Subject: 99 Victoria Drive Bognor Regis PO21 2DZ - BR/3/22/DOC

Planning Application: BR/3/22/DOC

Location: 99 Victoria Drive Bognor Regis PO21 2DZ

Condition 13 – Electric Vehicle Charging

PROPOSED SITE/LANDSCAPE PLAN

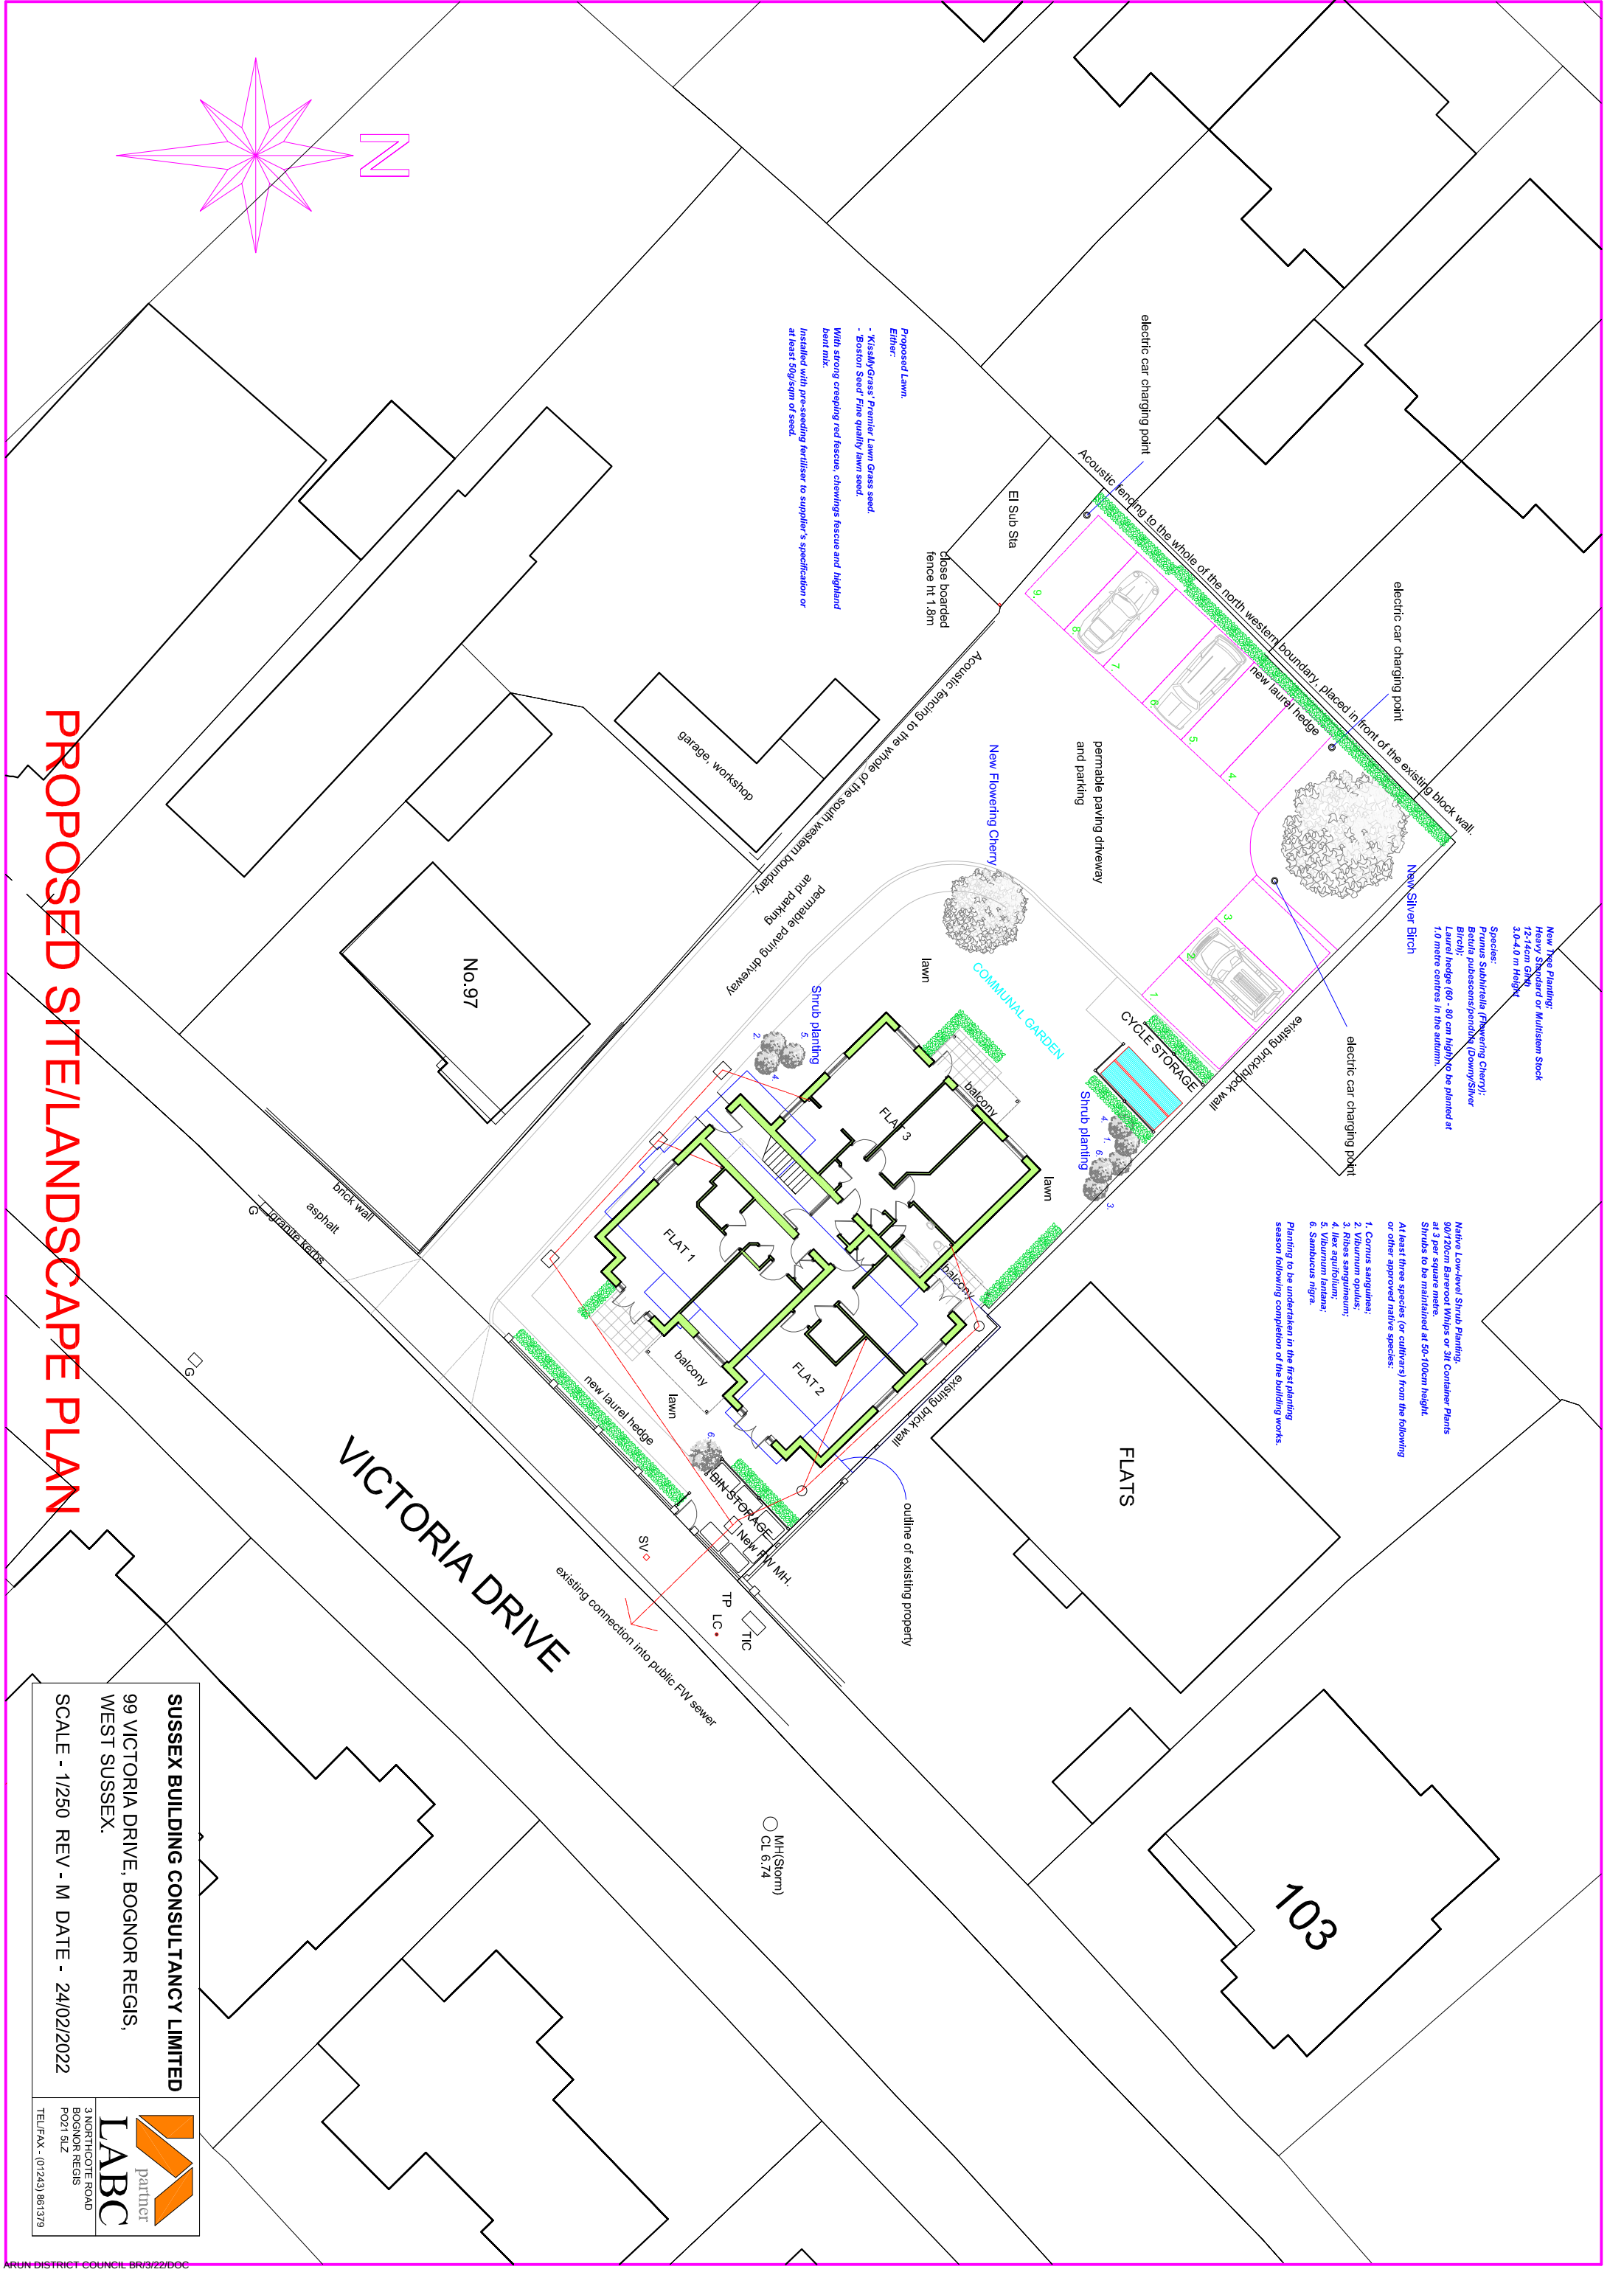
Having reviewed the amended proposed site/landscape plan, I am satisfied the number of electric vehicle charging points proposed is adequate for the proposed development, I therefore recommend the condition can be discharged.
